**21910 Enoch Road Kennel, AL-18-029**

Please accept the following comments from El Paso County Public Health regarding the project referenced above:

1 PLAN - SITE
SCALE: 1:200

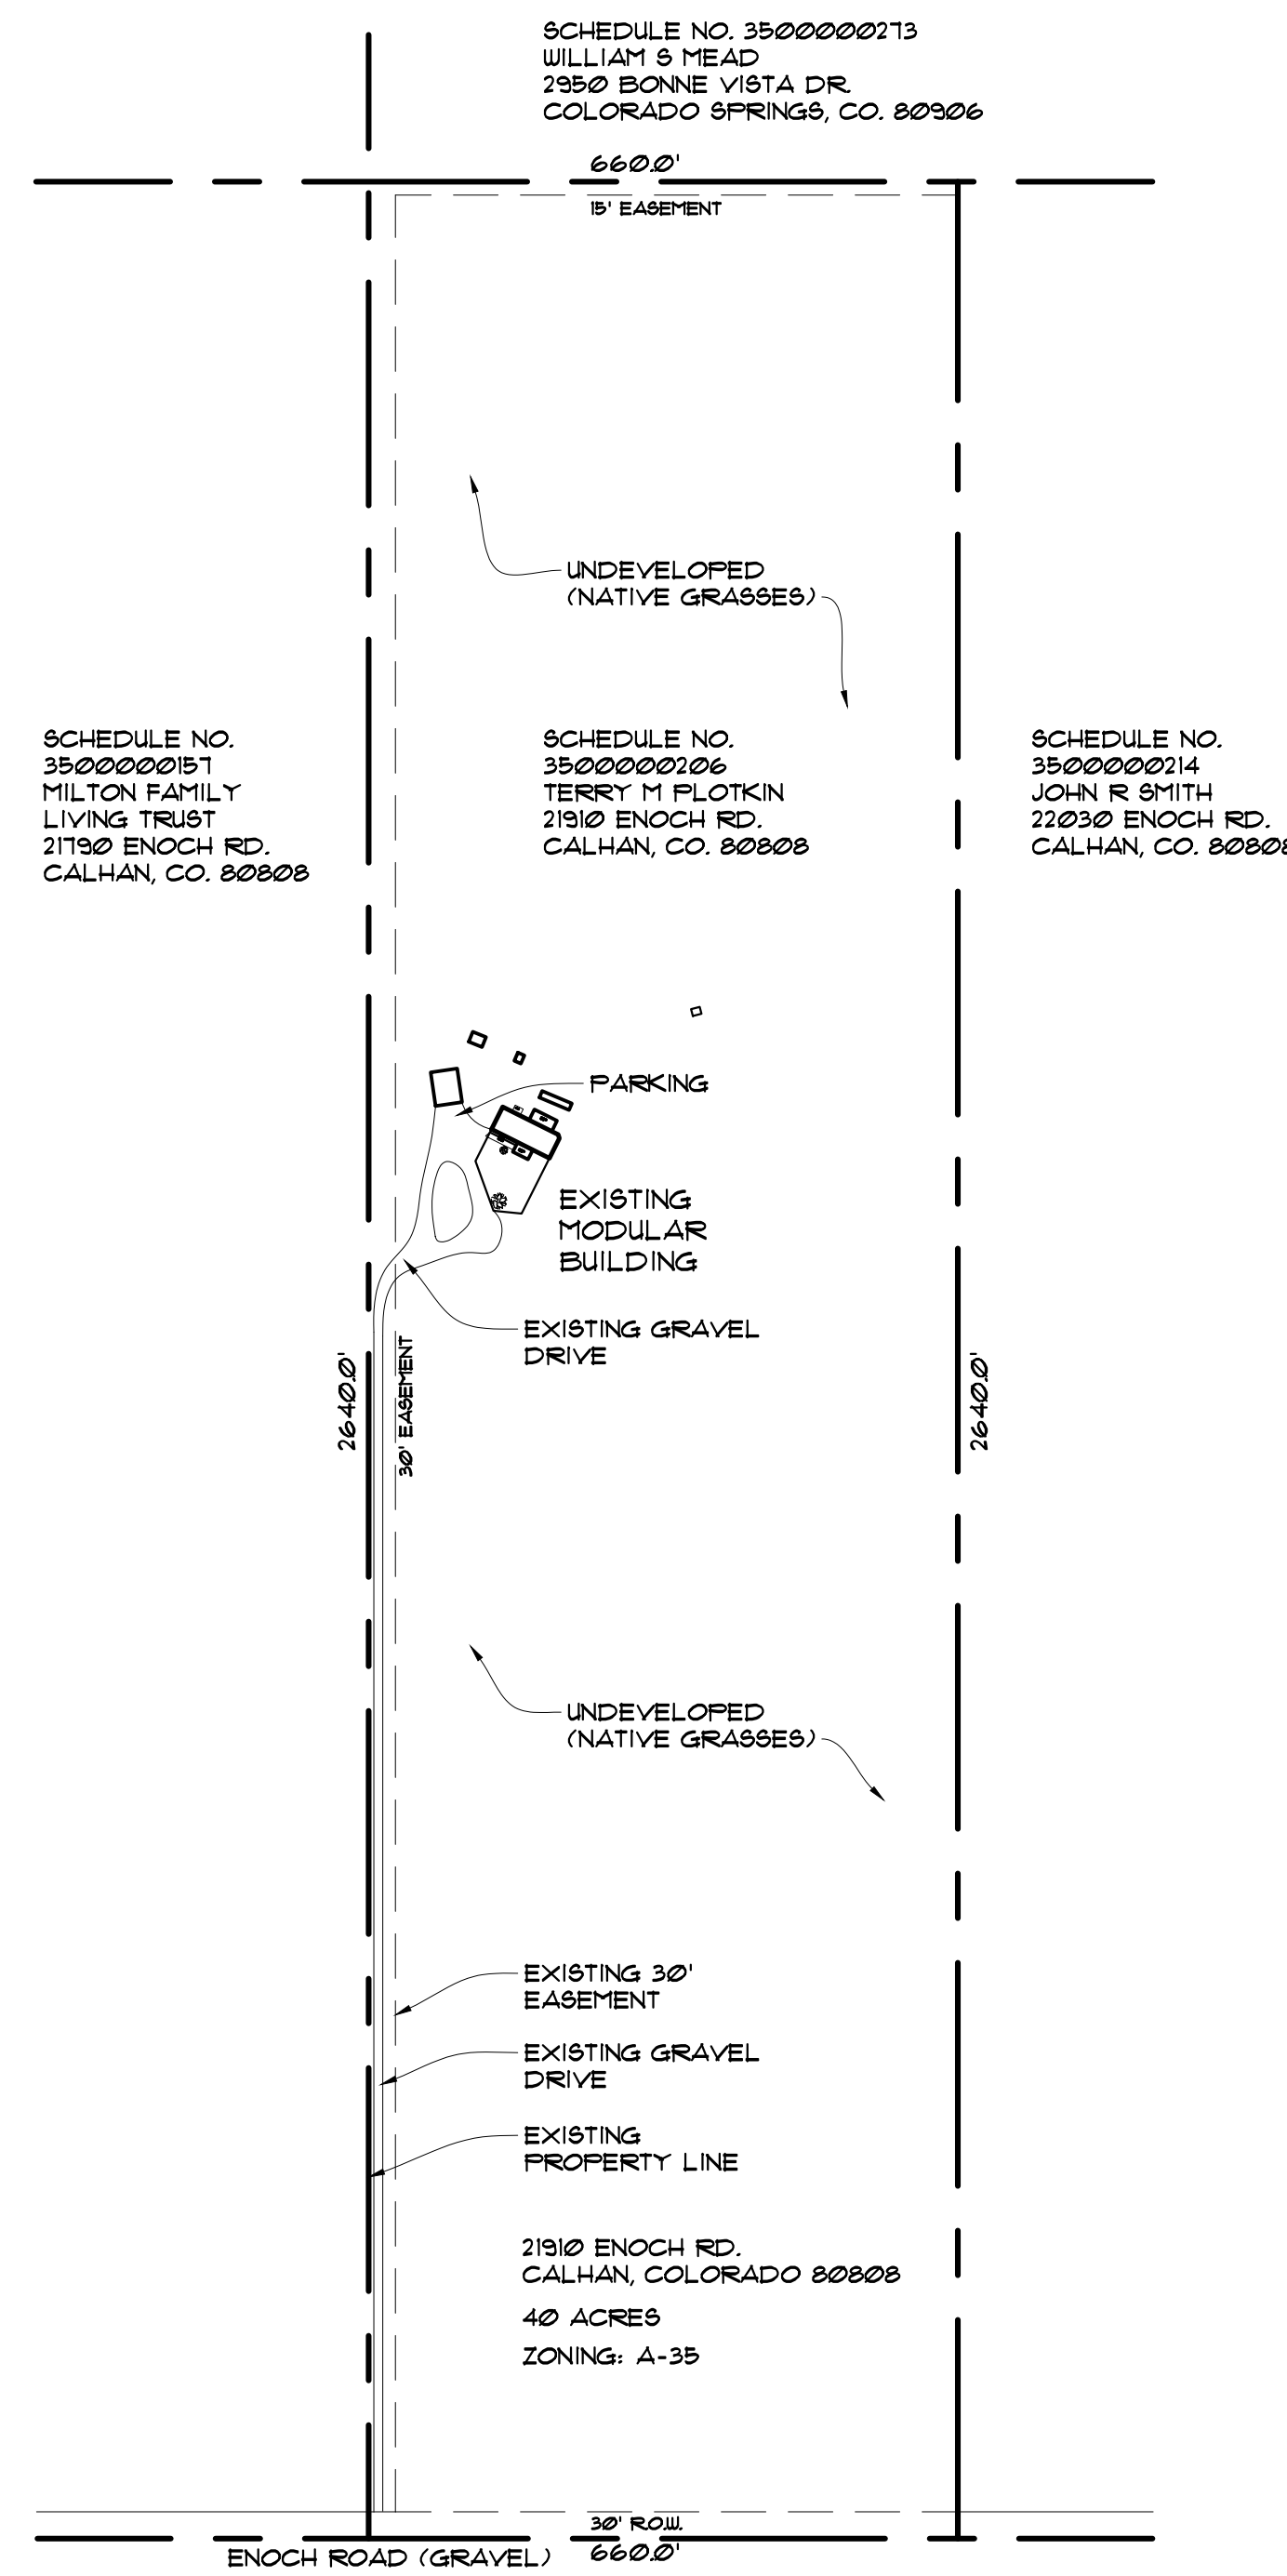
- A record of an approved, permitted on-site wastewater treatment system (OWTS) for this property indicates the OWTS was installed and approved for a 3 bedroom residence in 2000. The OWTS component locations are on file at El Paso County Public Health and accessible through the El Paso County Assessor's Office website property search page. Please make sure the components of the OWTS are protected from vehicular traffic and other means of compaction.

1 PLAN -
DP-2 SCALE: 1/4" = 1'-0"

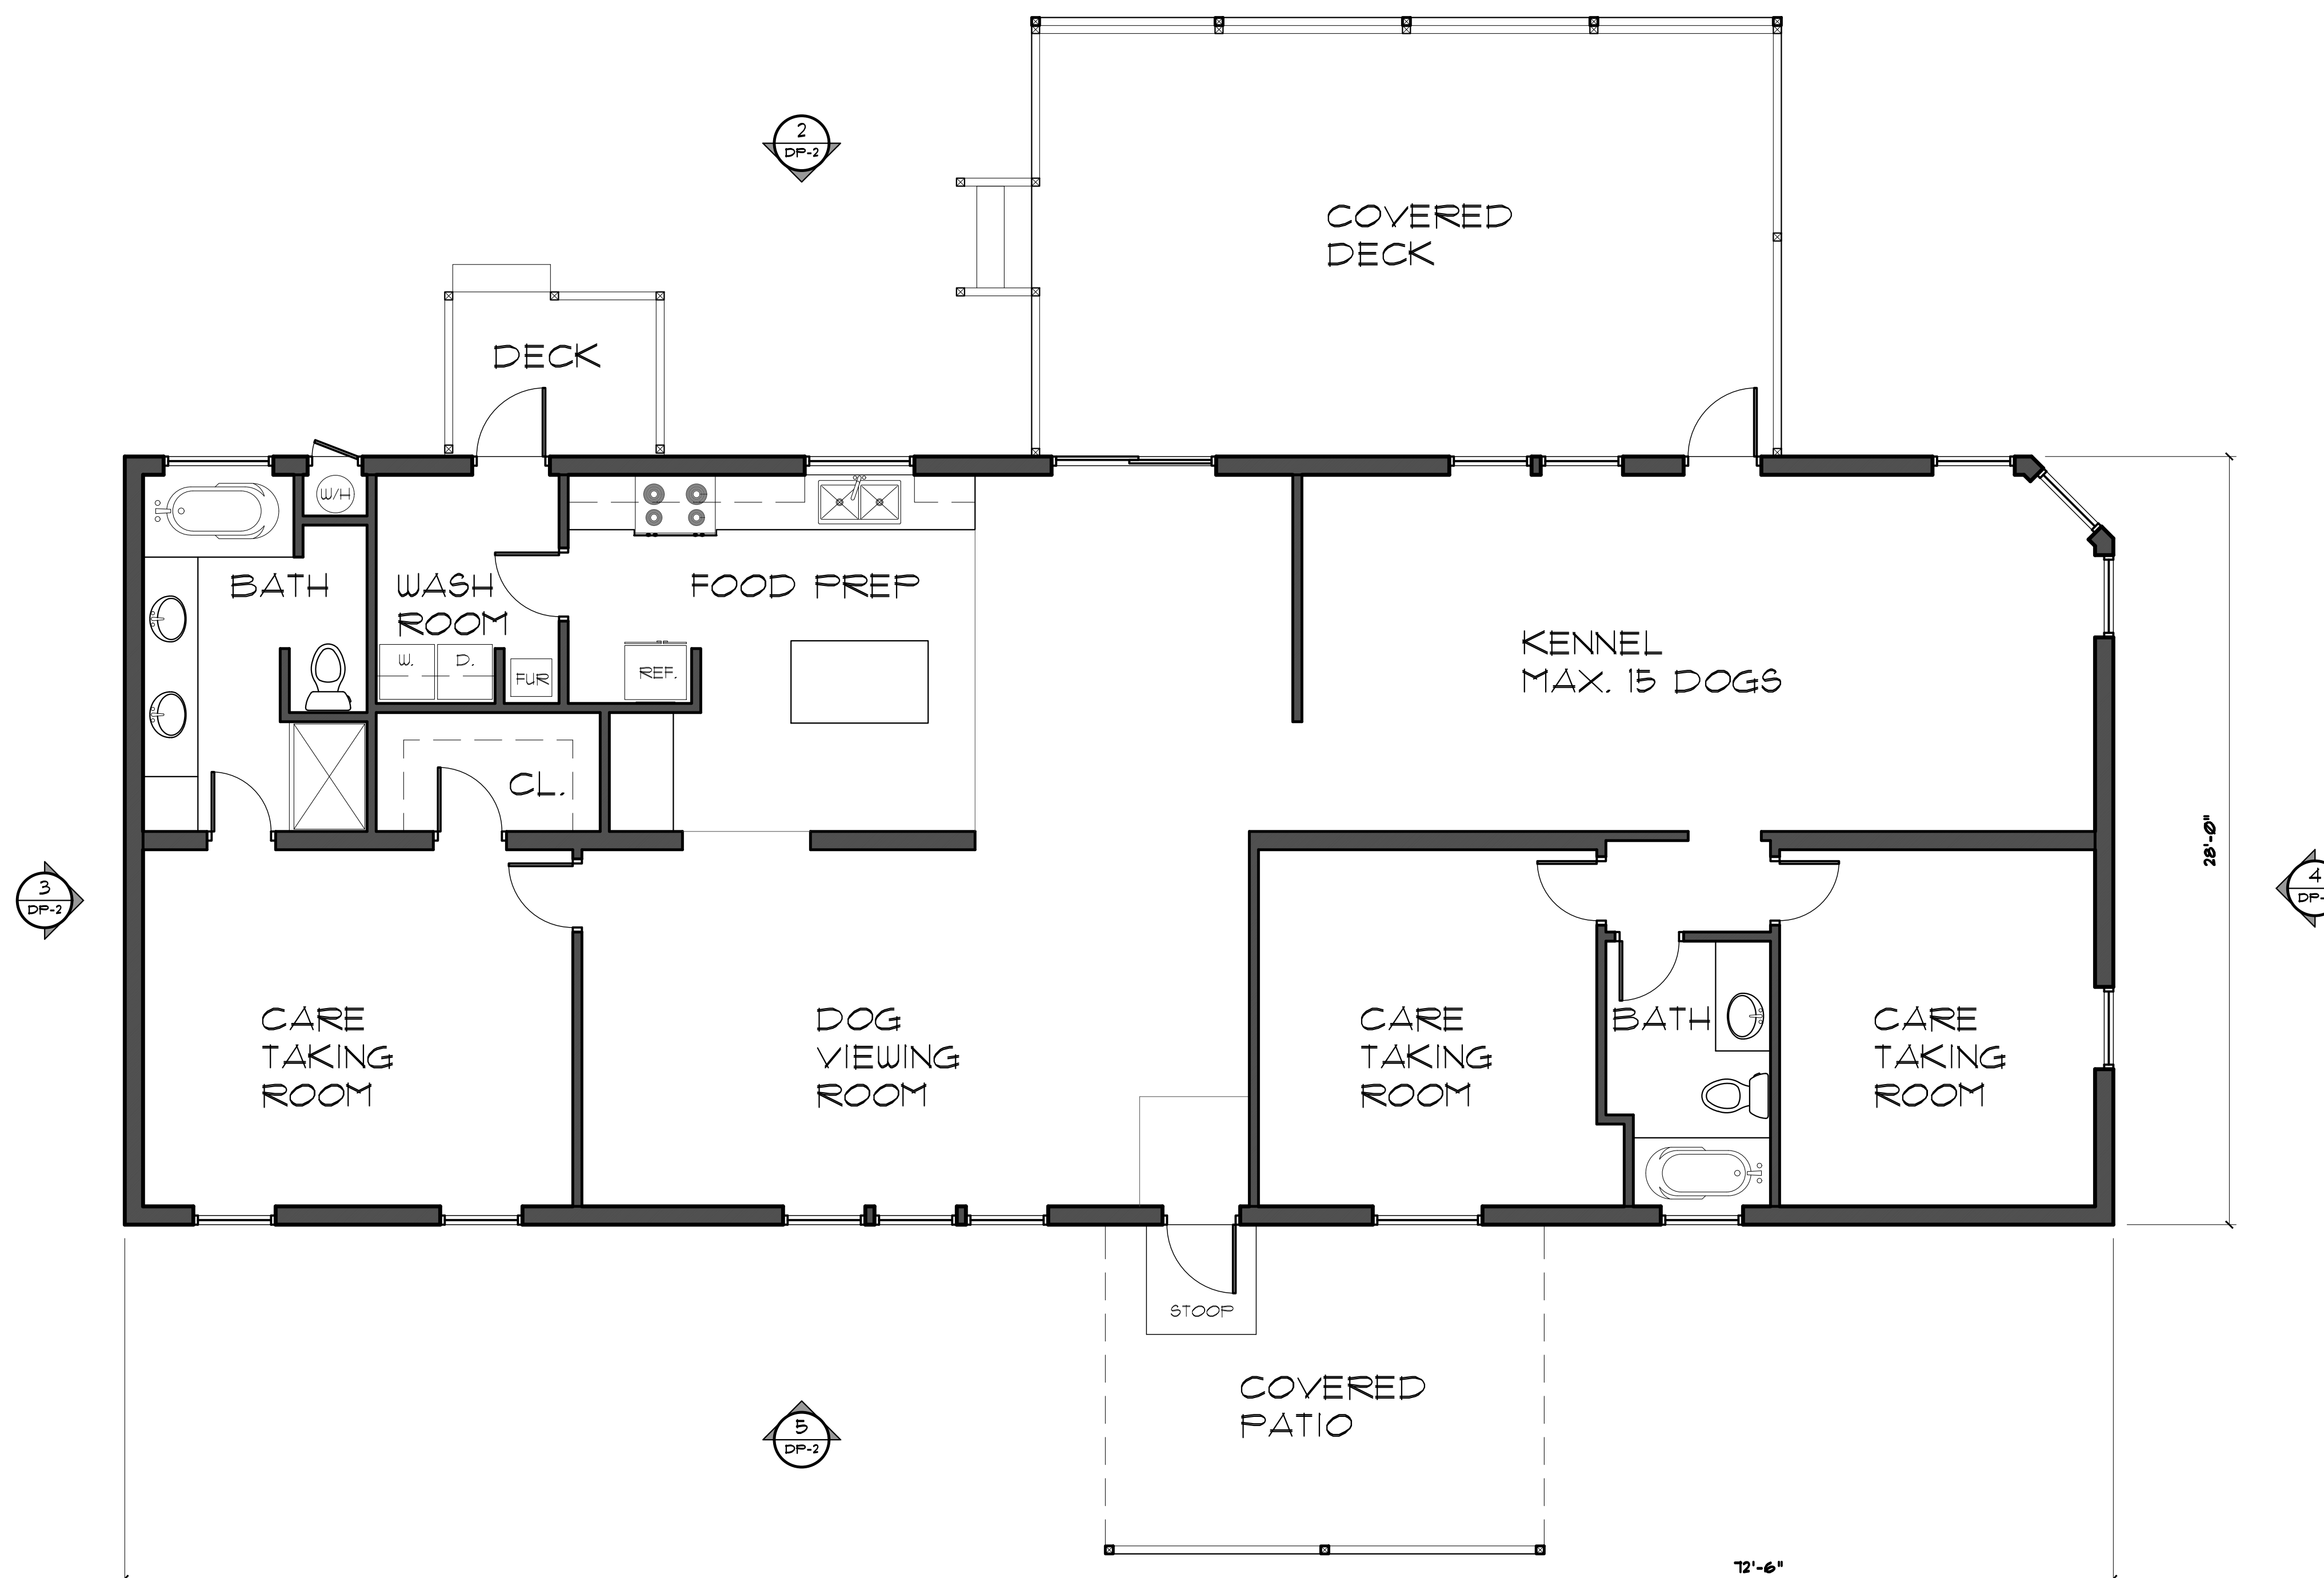
- The kennel operation is proposed to be located inside the existing residence connected to the approved OWTS located to the north of the house/kennel. Based on the floor plan no one will be living in the residence turned kennel.
